From: Ron Meyer <Ron.Meyer@lendlease.com>
Sent: Friday, 4 July 2014 5:06 PM
To: Matthew Rosel
Subject: RE: SSD 5752 MOD2 - S96(1a) application, further information request
Attachments: Actions_-_DRP_Meeting_190214[1].pdf

From: Matthew Rosel [<mailto:Matthew.Rosel@planning.nsw.gov.au>]
Sent: Friday, 4 July 2014 3:20 PM
To: Meyer, Ron
Subject: SSD 5752 MOD2 - S96(1a) application, further information request

I have almost completed my draft report and instrument for the S96(1a) application. After analysing the information in detail I have three questions that I would appreciate a response to:

SCALE @ A1 (50% @ A2) DRAWN: LM CO-ORD: DH REVIEWED: [Signature] APPROVED: [Signature]
PROJECT NUMBER: 003688 DRAWING NUMBER: CO_AR_D_200000 REV: H

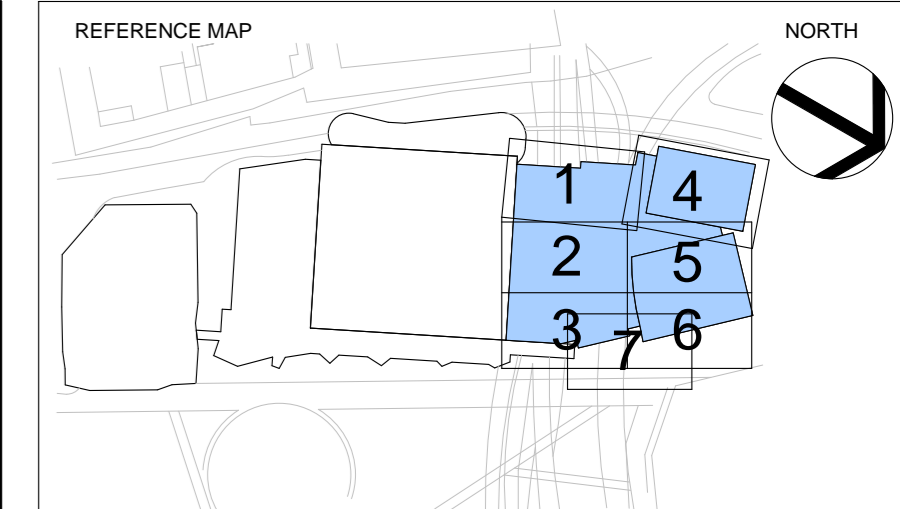
2. It is not clear from the plan whether the location of the security boom gate would result in a waiting service vehicle obstructing traffic on the Darling Drive south bound lane. Can you please confirm whether there is at sufficient space to allow for at least one service vehicle to dwell (while waiting for security clearance) without obstructing south bound traffic; *and*

3. Due to the location of the security booth and the extent of drawing CO_AR_200000H, it is difficult to interpret the relationship of the booth with the vehicle entry, Darling Drive and the loading dock. Can you please provide an additional clarifying plan (refer to image below);

- 1) Find attached meeting minutes from INSW dated 19 February 2014 – refer Item 20 confirming Design Review Panel support for screen.
- 2) The location of the security hut is important as it must be located before the rejection lane which is shown on the plan. So if security team reject the truck from entering the Exhibition loading dock it can go back out onto Darling Drive before driving up the ramp into the loading dock. So it will cater for one truck but we will do an overlay to demonstrate this
- 3) I will get a drawing issued to bring all the elements requested together.
